Application no: H16-0272-15

Description: Proposed conversion of outbuildings to residential units

Location: WELLAND HOUSE
30 HIGH STREET
SPALDING
PE11 1UB

Amendment: Proposed refuge provided to bedroom
(Dwg. no. 15664-06 Rev A)

ROOF PLAN 1:50

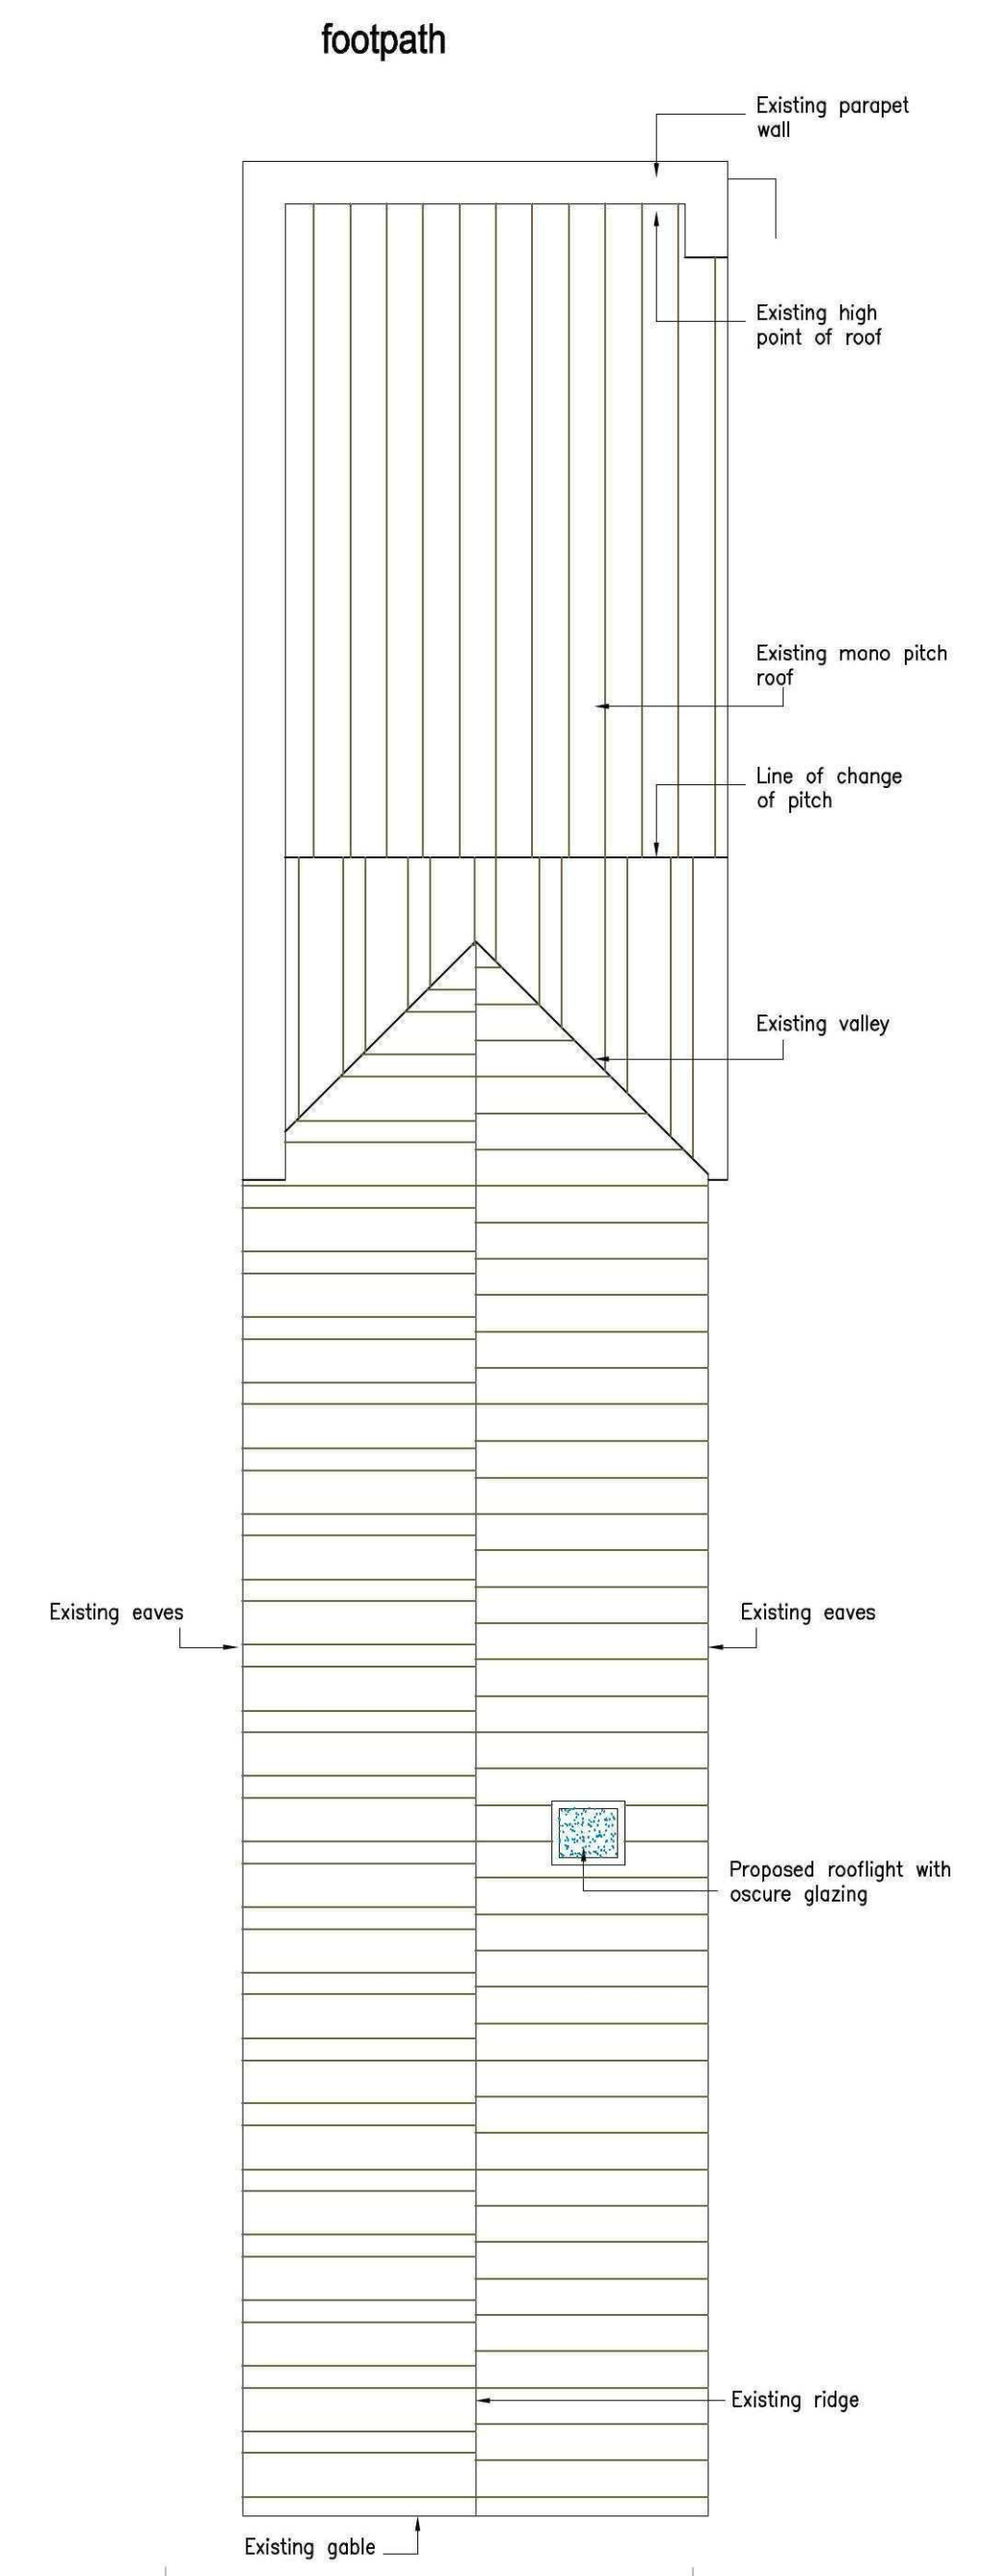
Further to discussion with Richard, please find attached amended drawing with a Refuge Area included to the front unit to appease the EA comment.
